Recommendation Report for Planning Permission for Works or Extension to a Dwelling

REF NO: BE/5/22/HH

LOCATION: 2 Old Moat Close
Bersted
PO22 9UP

PROPOSAL: Retention of a rear orangery. This application may affect the character and appearance of the Shripney Conservation Area.

PROPOSED Plan View

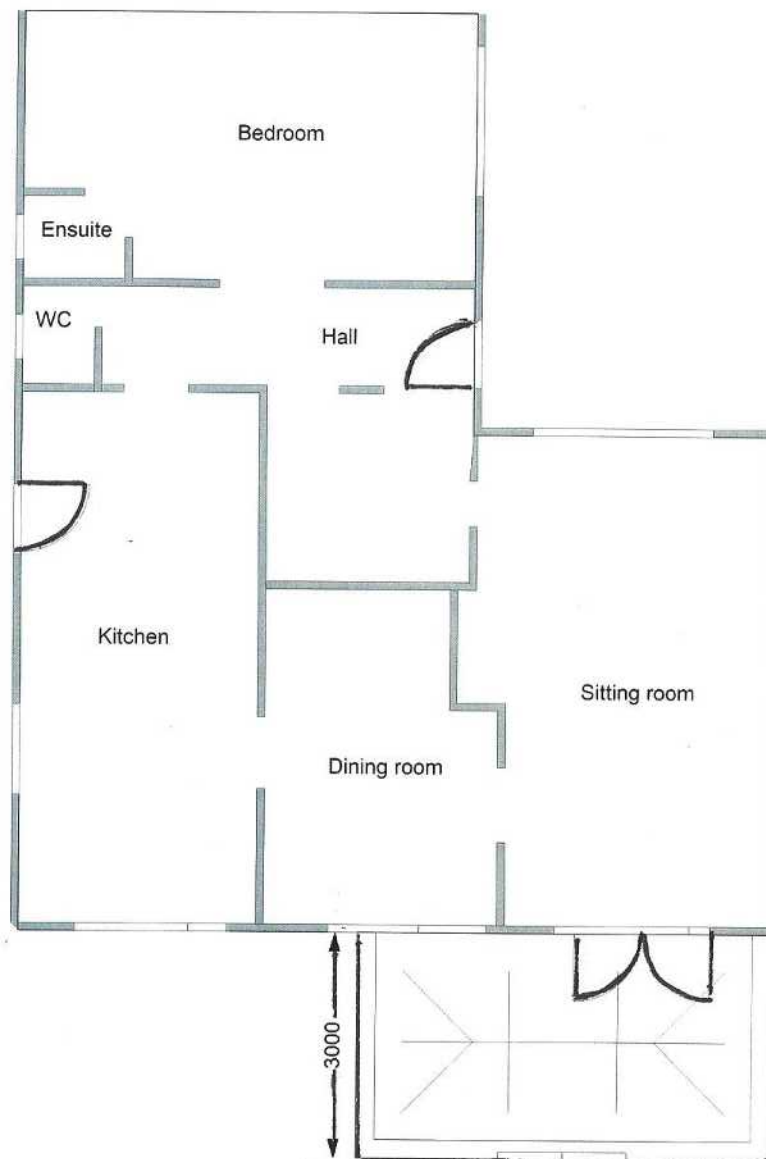
The orangery is a modest size, with a width of 5.5m and depth of 3m. It has a flat roof, with a glass roof lantern, which although differing to the pitched roof of the host, does not appear unduly out of place with the character of the property. It has no adverse impact on the visual appearance of the property and is sympathetic in design to the existing. The property itself is situated in a small residential close, comprised of a few properties, all of which detached and of varied design and style. Being to the rear, the orangery is not visible from within this close, and has no impact on the visual appearance or composition of the property, or its locality. It is however visible from the street scene to the rear, but this visibility is restricted by a brick and flint wall which runs along the boundary. As a result, the orangery does not unacceptably intrude on this street scene and has minimal impact on the character and appearance of the area.

The development is single storey and has a flat roof measuring approximately 2.4m high. This roof incorporates a glass roof lantern, which protrudes above at a height of 3m, and spans much of the roof area. This lantern poses no risk of adverse harm to residential amenity, considering its scale and location, and is acceptable. The orangery itself retains approximately 5.43m from the east, 6.54m from the north, and 0.8m from the west boundaries. The west boundary is the only boundary shared with a

neighbouring property, and as such is the only property at risk of any impact posed by the development. D DM4 of the Local Plan and Arun Design Guide recommends that extensions keep at least 1m from neighbouring boundaries, of which the development does not comply with. However, given the staggered nature of the properties positionings within the close, the orangery does not unduly overbear or overshadow No.1 to the west, despite its distance from the boundary, and is considered acceptable, having little harm on residential amenity.

PROPOSED Right Elevation

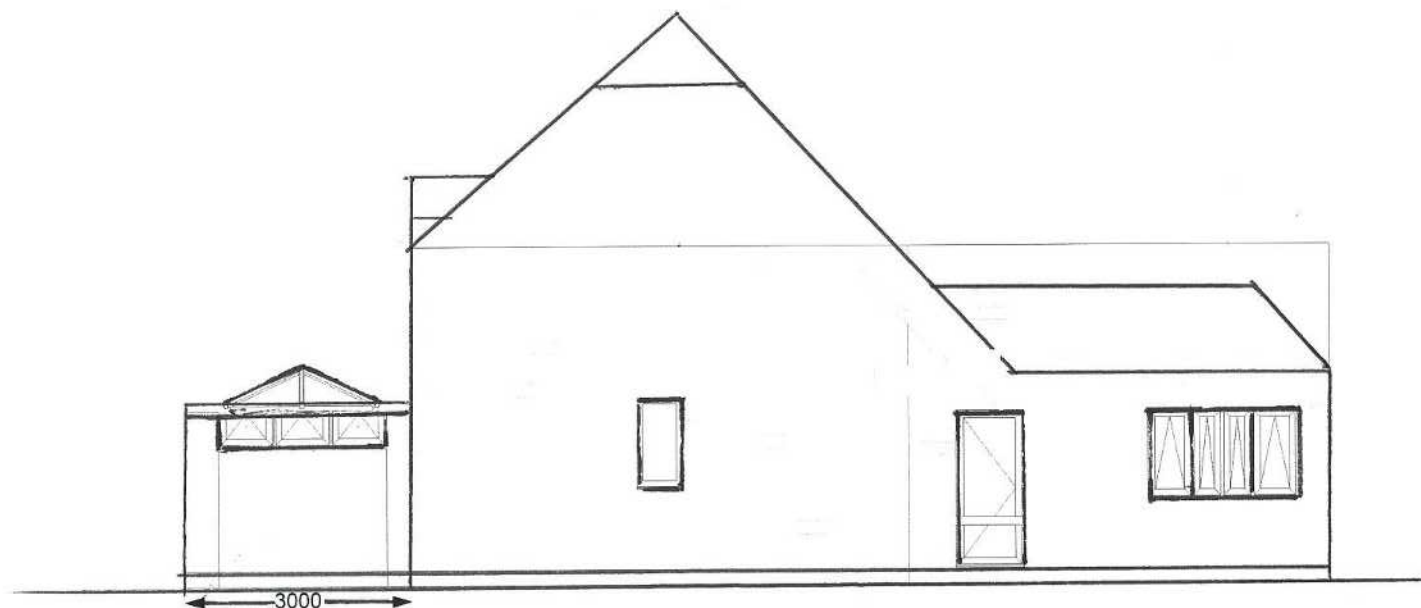
In addition to the roof lantern, the orangery features windows and a set of French doors to the north (rear) elevation, windows to the west, and windows to the east. The features to the east and north elevations do not face towards any neighbouring properties, and as such have no harm on neighbouring privacy or amenity. The windows to the west face towards No.1 and pose a risk of overlooking. Although facing this neighbouring property, the windows themselves are situated high up on the elevation and cannot be easily looked through. As such, they provide limited visibility of No.1 from within the orangery, and are acceptable, having little harm on residential privacy and amenity.
